# Parramatta West Public School Redevelopment Modification 2

State Significant Development Modification Assessment  
(SSD-8790-Mod-2)

November 2020

Ground Floor - Demolition Plan - South Site B00B and B00D

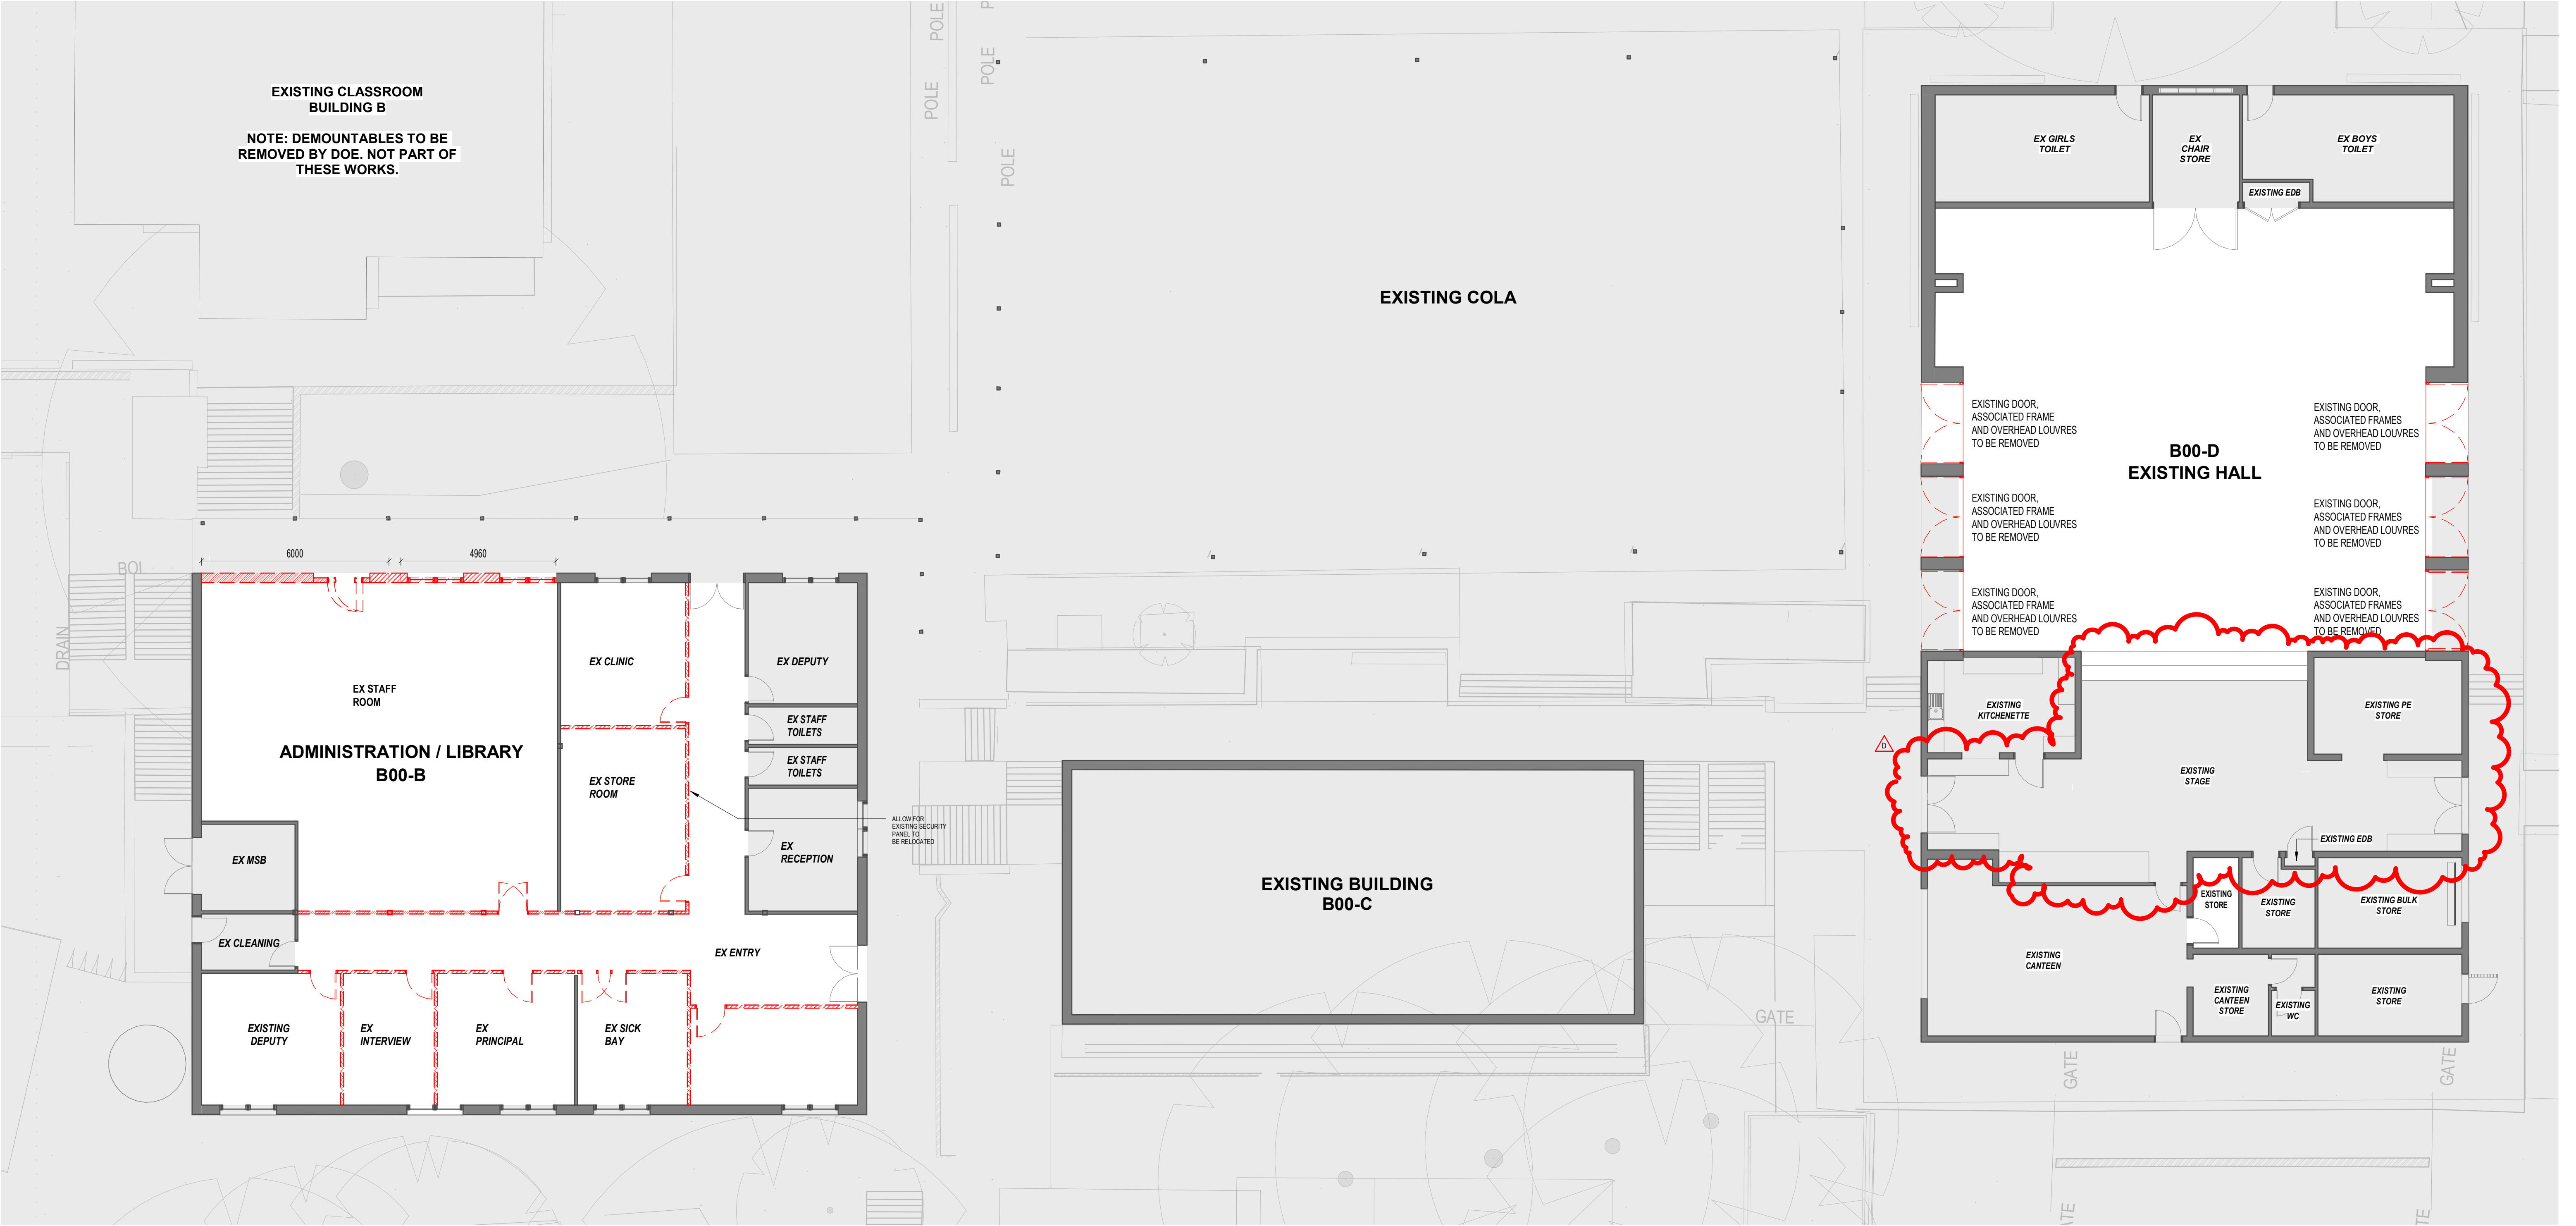
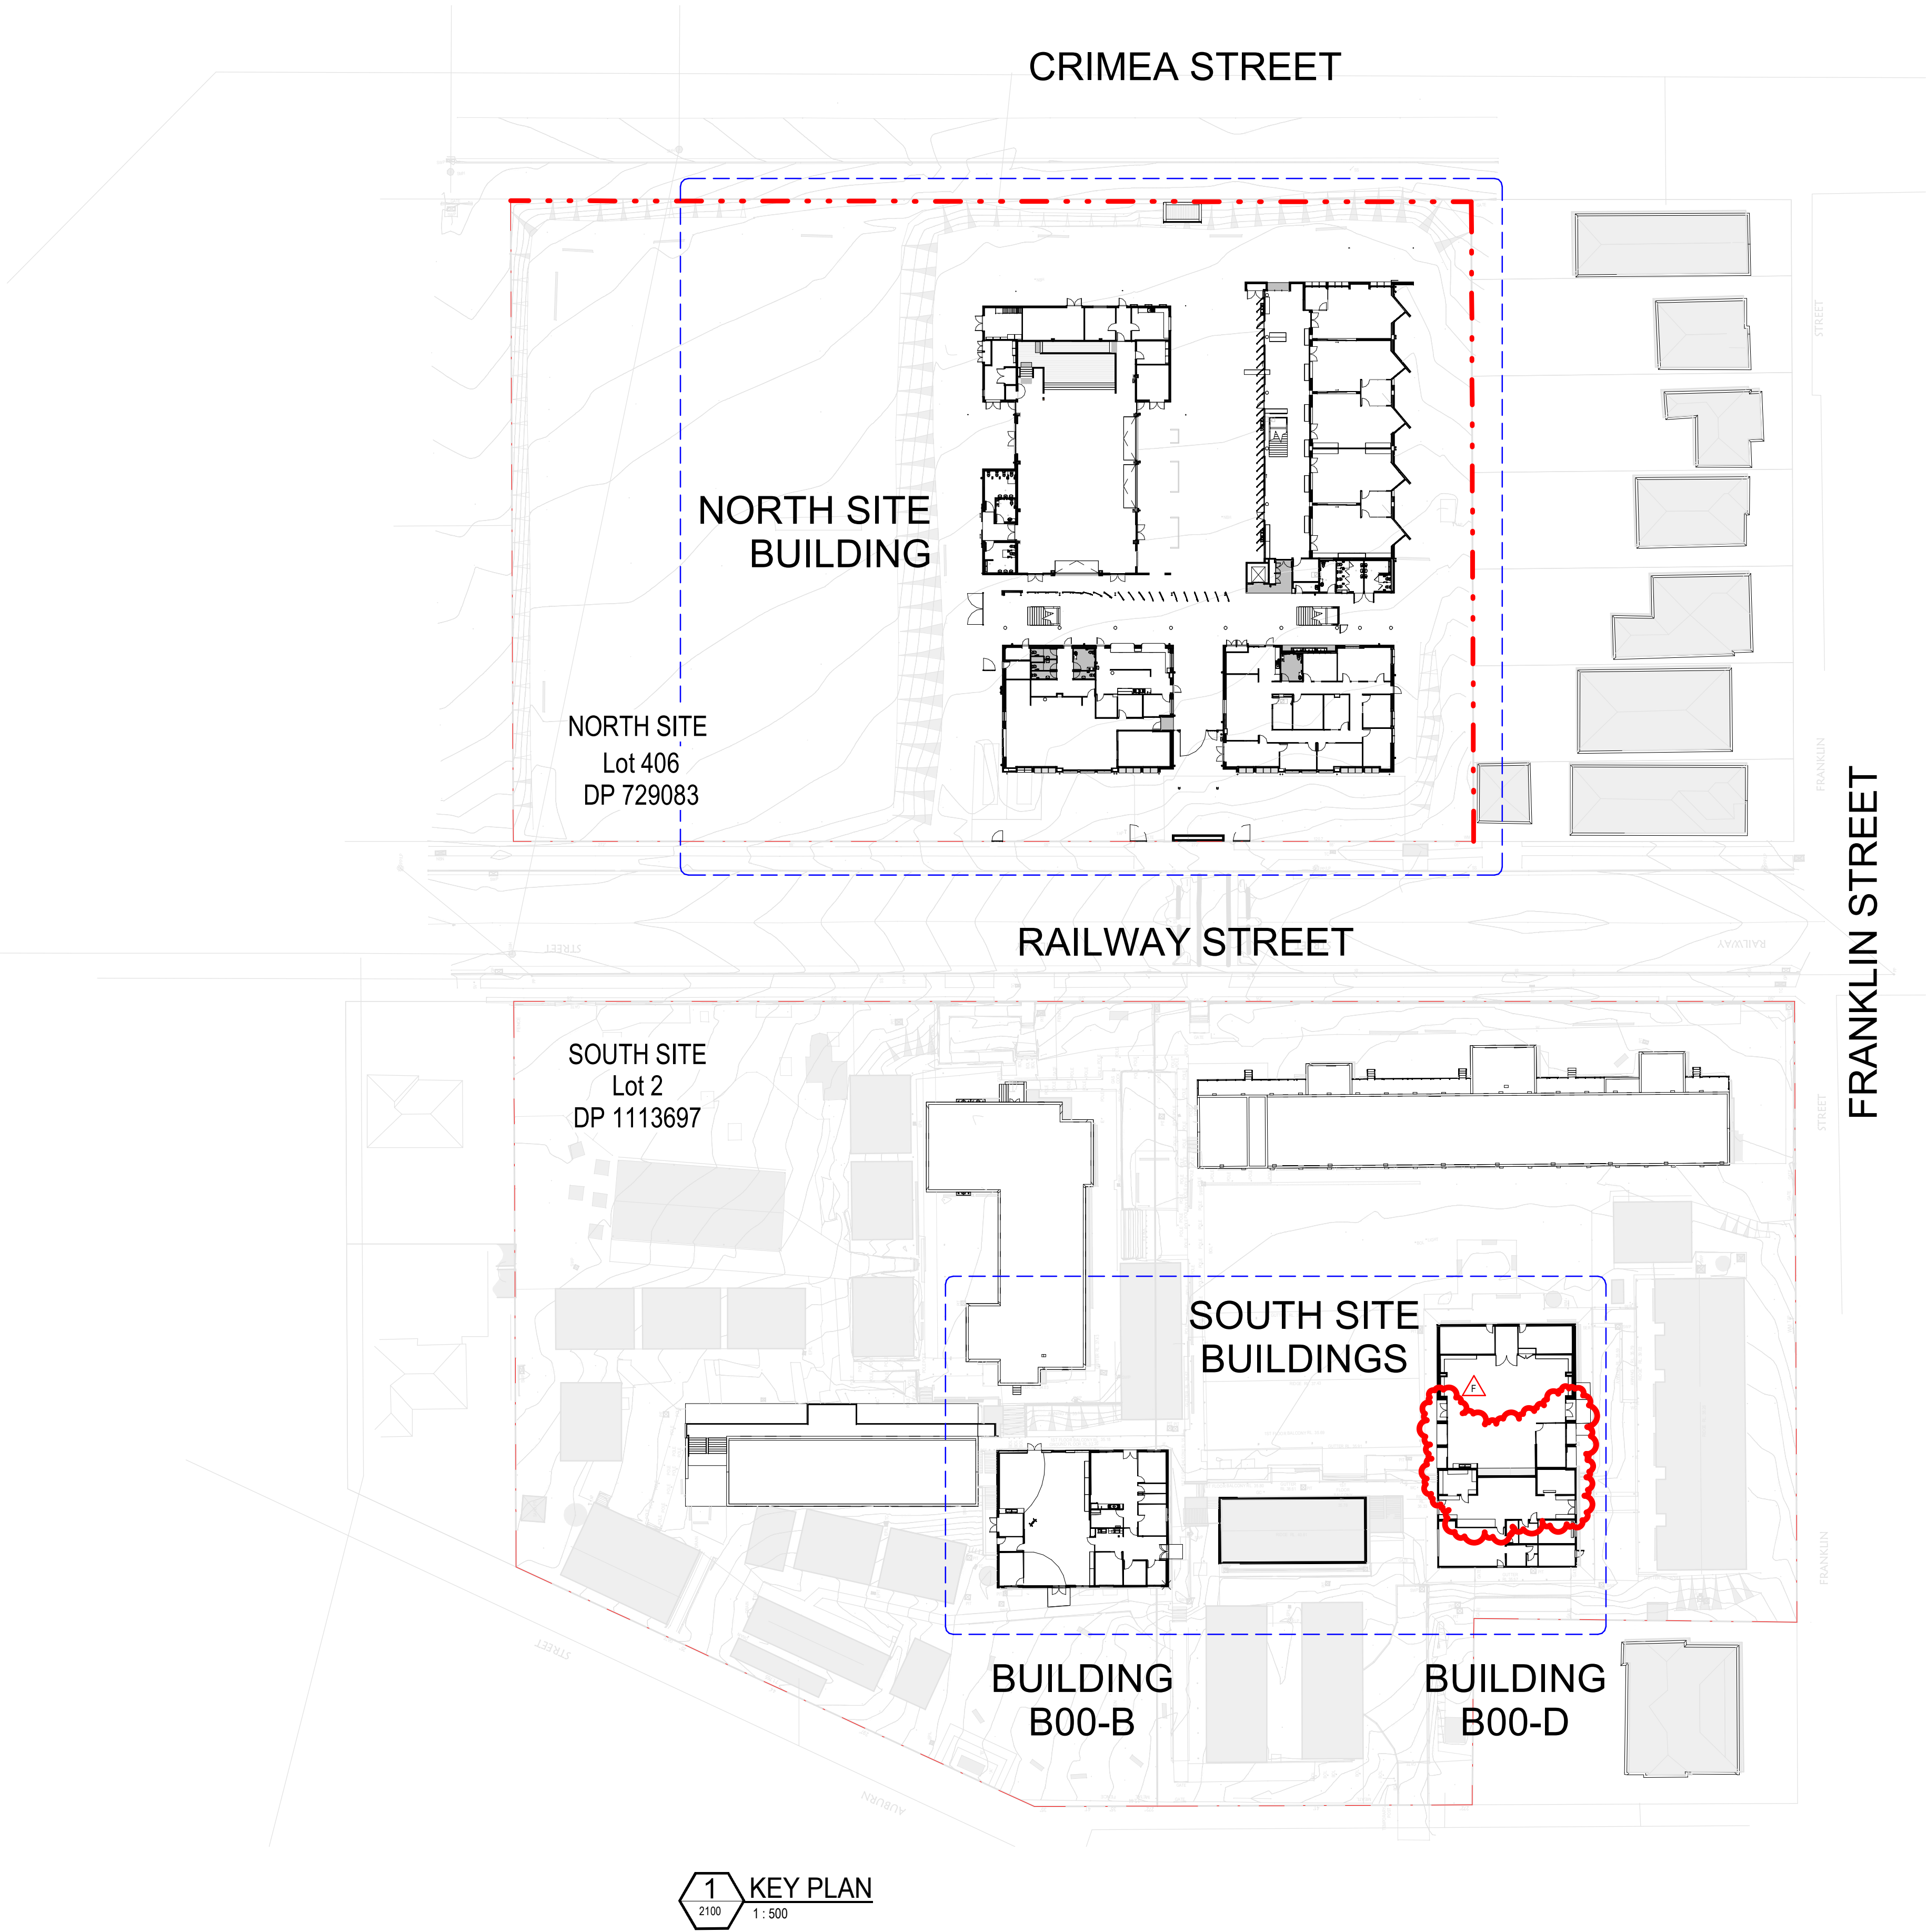
The deletion of the internal ramp is considered appropriate given the inclusion of the new external ramp. The Department acknowledges that the purpose of the internal ramp was to provide equitable access from the home base area to the withdrawal teaching space and practical learning area. The new external ramp would still provide equitable access to the withdrawal teaching space and practical learning area, now relocated.

Figure 4: Proposed Plan - Building B00-D

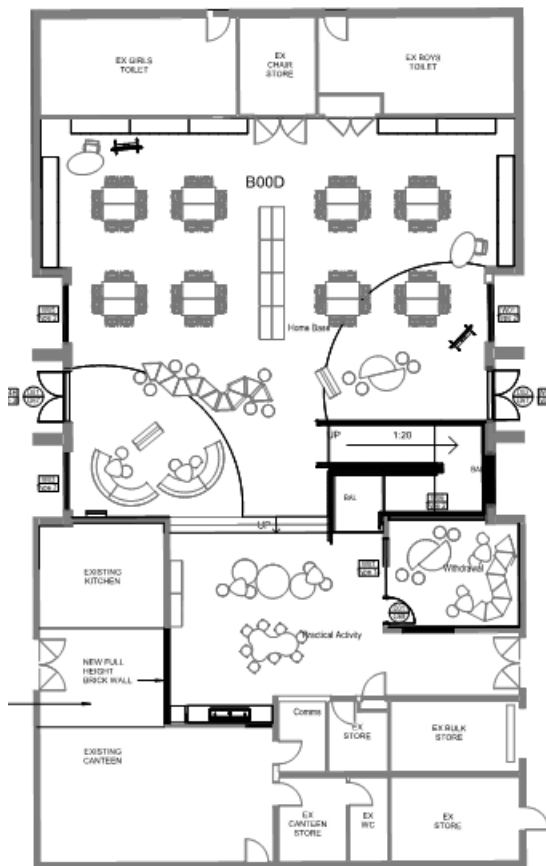
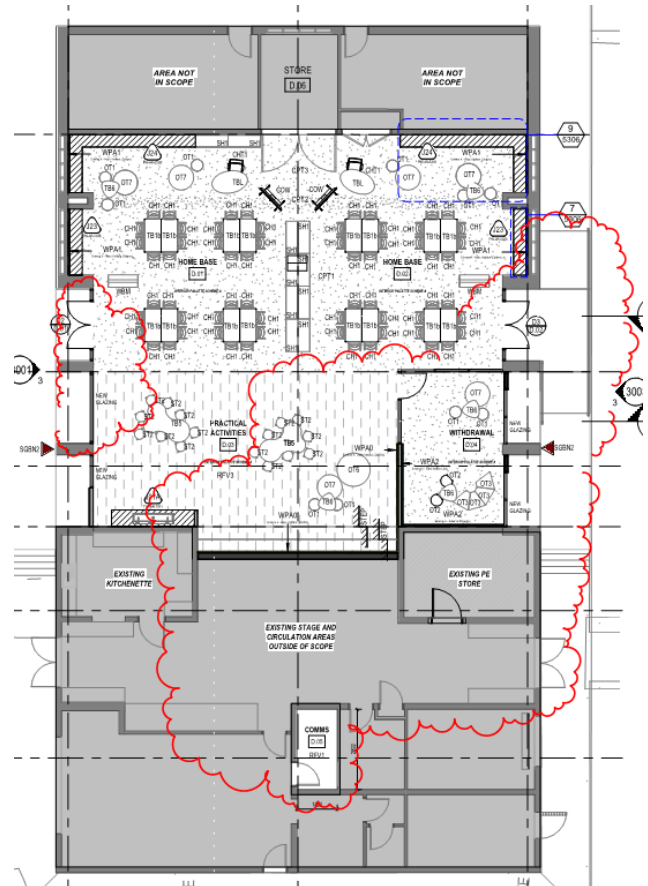
The Department notes that the doors to be relocated on the eastern and western elevation are in the place of existing window openings. The amendment would not create new openings in Building B00-D and would not alter the general appearance and design quality of the approved development. The amendments to the internal doors, including new door from the canteen area, kitchenette and water closet, would improve access throughout the building for staff in the southern section of the building. The proposed changes are considered to be acceptable.

The new location of the dividing wall is considered suitable to separate students from the learning area in the northern half of the building.

Overall, the Department considers that the relocation of the ramp, dividing wall, withdrawal teaching space and practical learning area adequately consolidates learning areas for students within the northern section of Building B00-D and separates staff areas in the southern side half of the building. The proposed modification is considered to be acceptable.

The retention of the existing internal storage area would not impact the use of the school or its learning facilities. The amendment is minor and would enable better separation between student learning areas and storage and staff areas. Overall, the proposal would not alter the quality of the approved development.

Figure 5: Proposed Elevations - Building B00-D

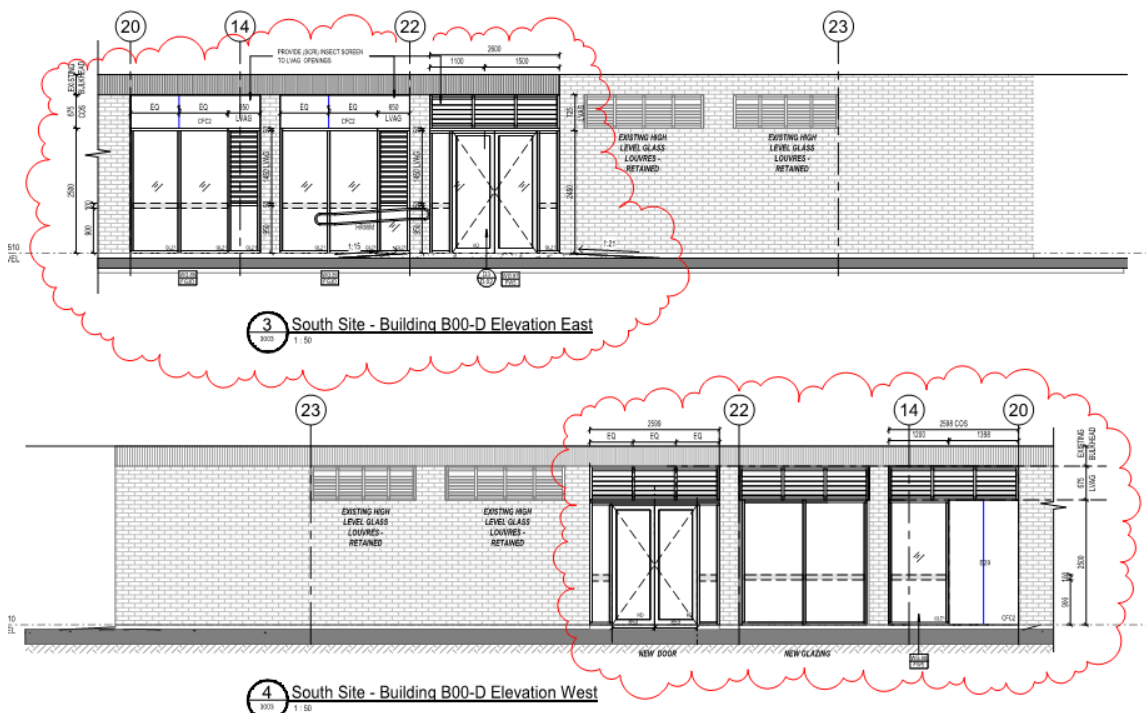
The proposed additional glazing to windows from the new withdrawal learning area is minor and considered to improve student learning amenity. The modification is not expected to impact the general appearance of the approved development.
